Ribble Valley Borough Council

**App no:** 3.2026.0194

**Address:** Land to the rear Horton Grange Horton Road Horton

**Proposal:** Proposed construction of garage on existing parking area.

Drawing No. 5152_03A

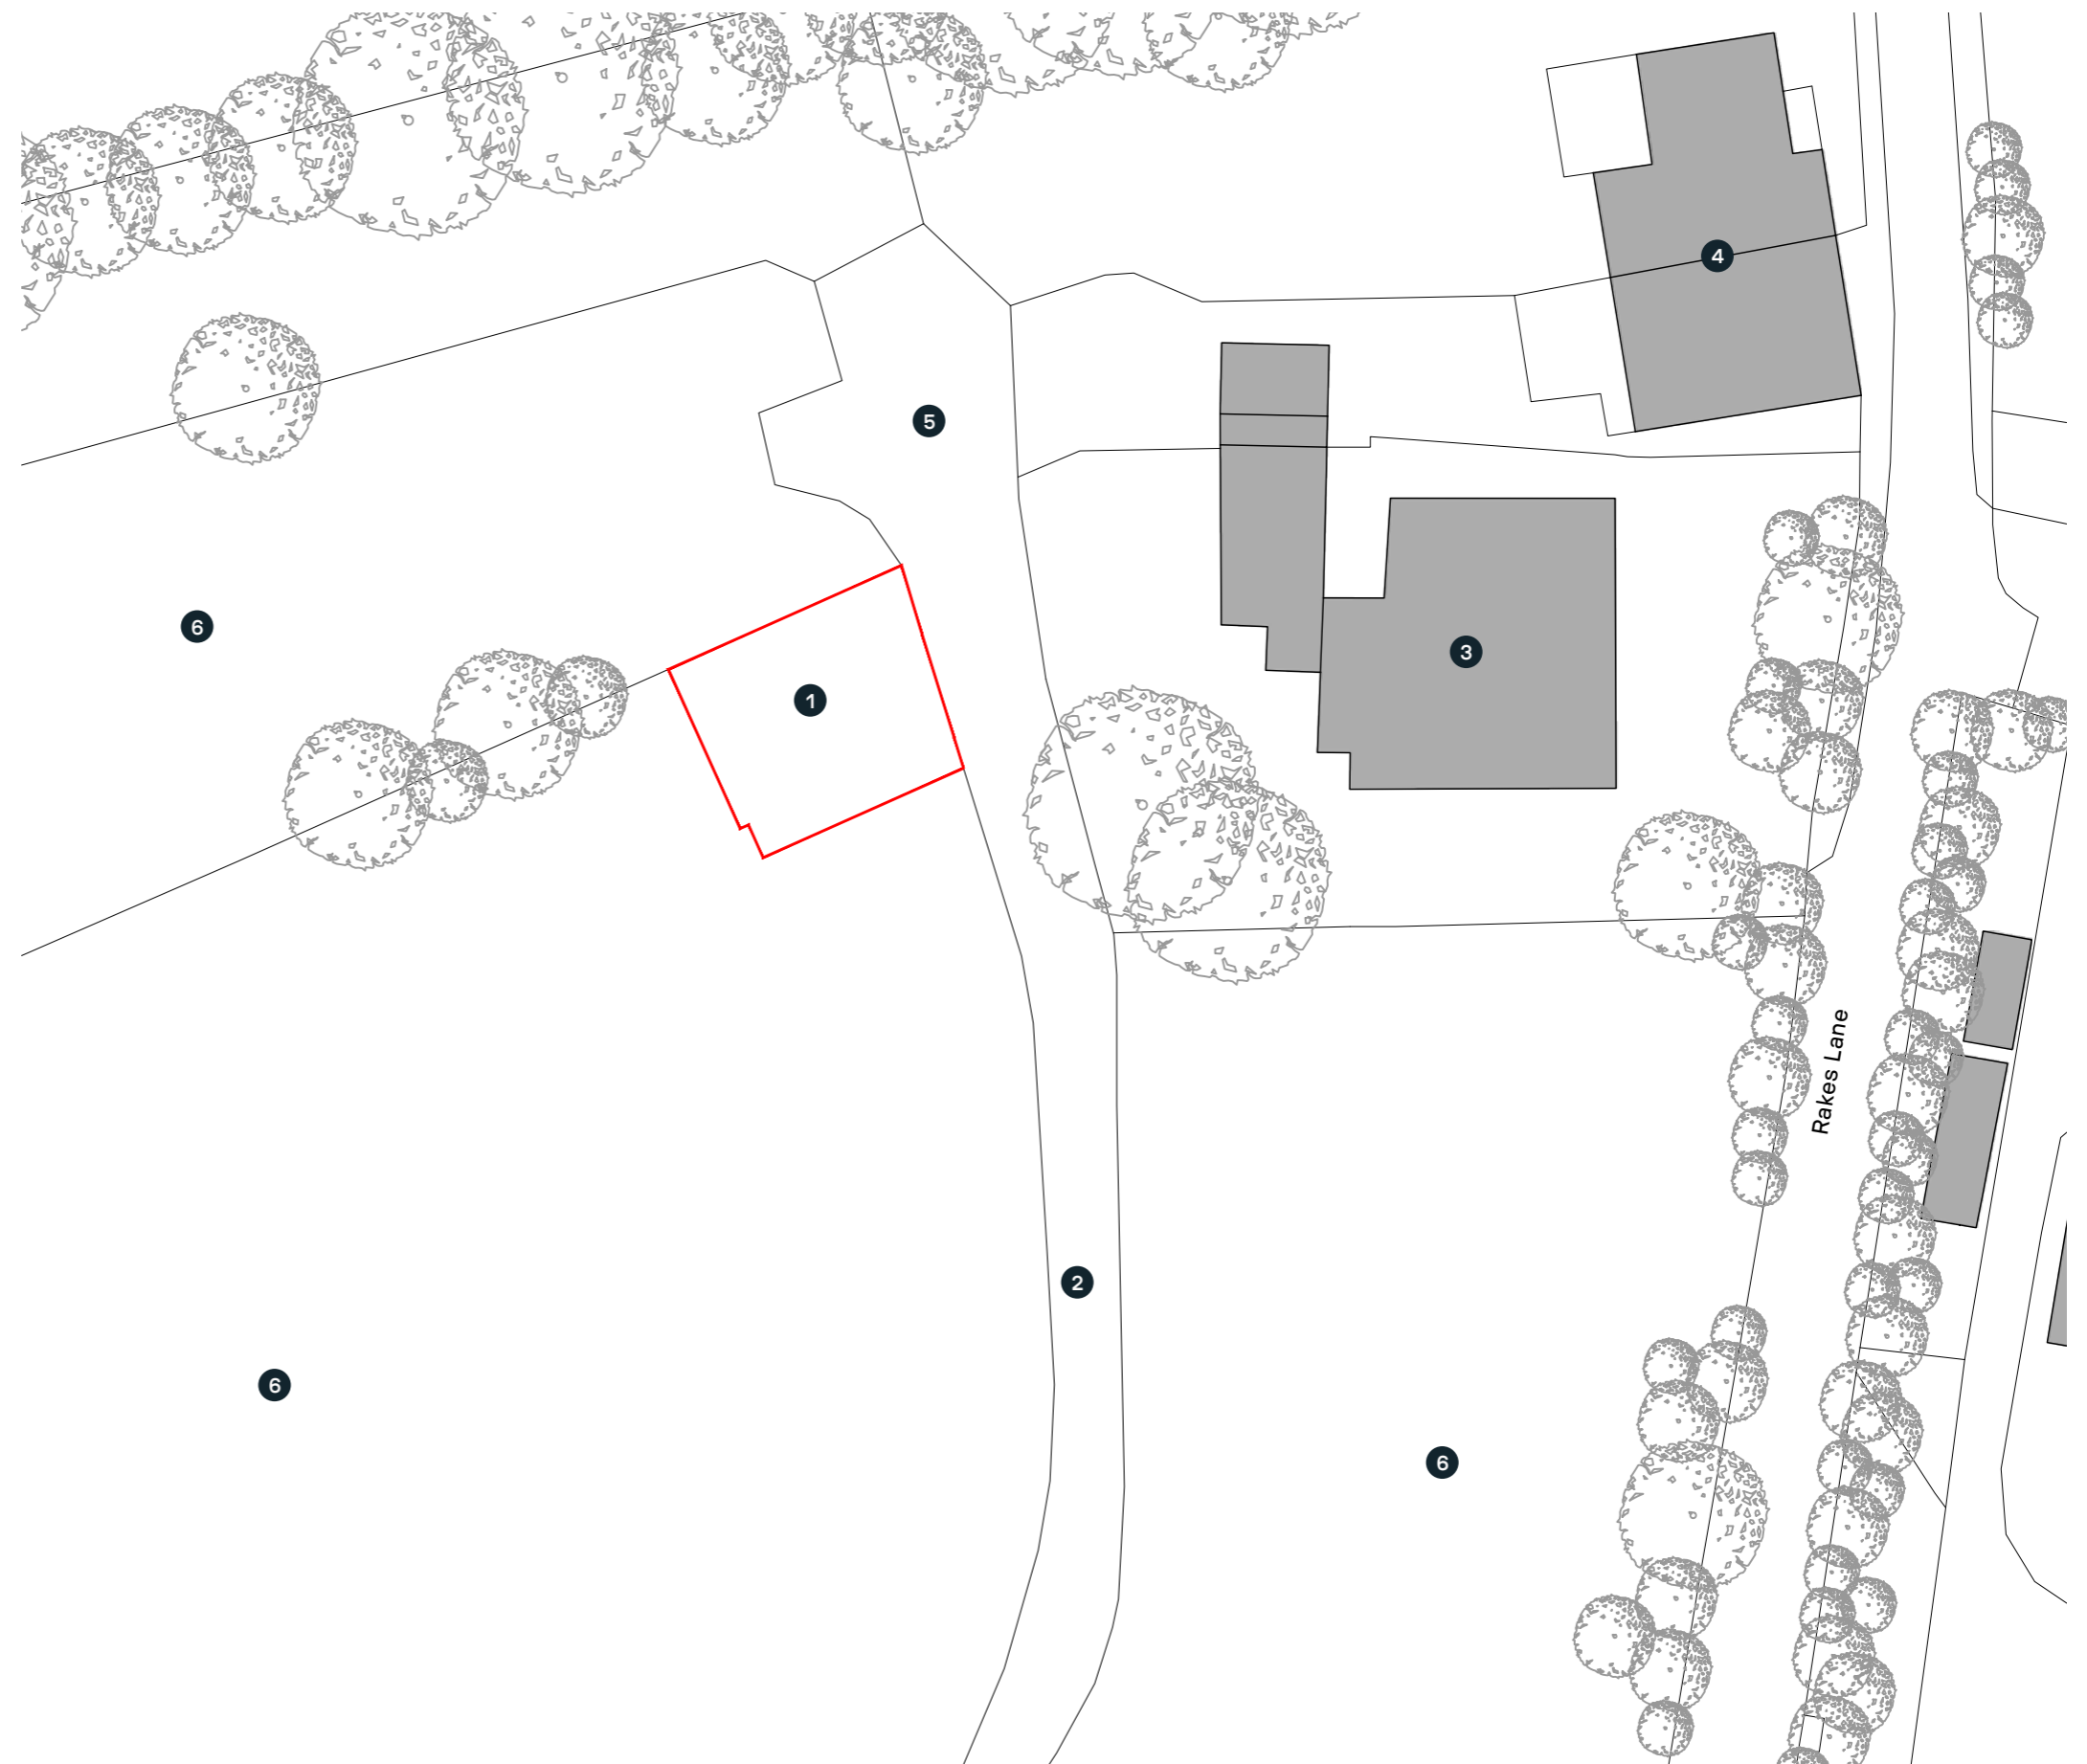
The garage is positioned close to the shared access road and provides no set back for a vehicle to clear the access road or any visibility if vehicles are exiting via the doors on the south elevation via the narrow permeable apron. This appears too narrow to be practical for use.

Notwithstanding this the access road is not recorded as highway and would only be potentially a matter for the neighbours who share the access road. To remove this concern the garage would be set back by 2m from the edge of the access road.
